Application for removal or variation of a condition following grant of planning permission.
 Town and Country Planning Act 1990.
 Planning (Listed Buildings and Conservation Areas) Act 1990

FOLLOWING: REMOVAL OF THE EXISTING OUTBUILDINGS AND CONSERVATORY, CONSTRUCTION OF DETACHED BUNGALOW WITH ASSOCIATED CAR PORT, REVISED DRIVE & LANDSCAPING

- CONDITION 2 : - COMPLIANCE WITH PREVIOUSLY SUBMITTED DRAWINGS - REPLACED WITH NEWLY SUBMITTED DRAWINGS.
- INTRODUCTION OF AN ADDITIONAL WINDOW TO FRONT ELEVATION AND OTHER MINOR ALTERATIONS TO THE ELEVATIONS.
 - CHANGE FROM A "GREEN ROOF" TO A SLATE GRAY CONC. TUE (MORTGAGE COMPANY TO NOT USE A GREEN ROOF)

CAR PORT DETAILS
Scale 1:100

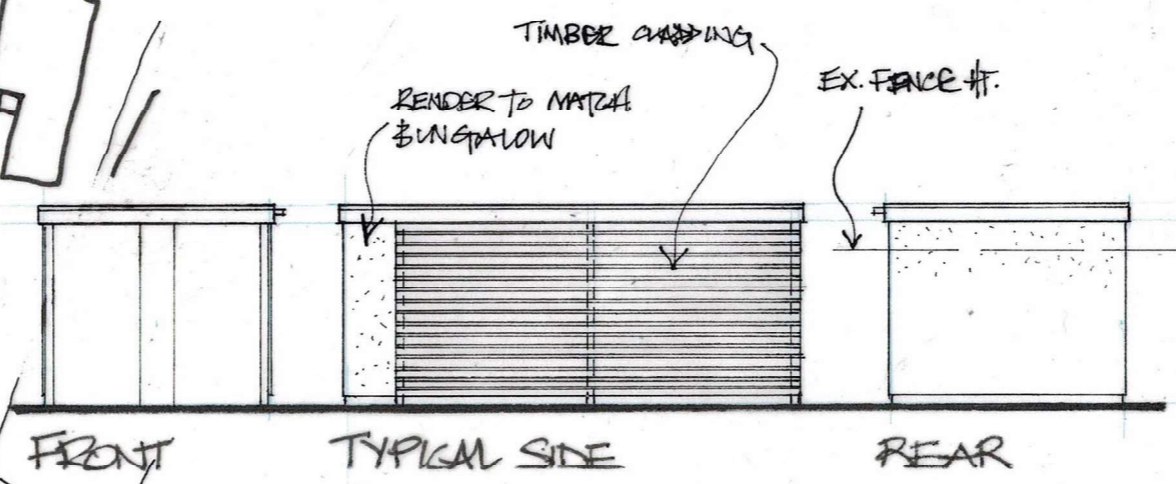
CONDITION 4 : - REDUCTION IN SIZE OF GARAGE TO A SINGLE SEE WITH ASSOCIATED PARKING SPACE.
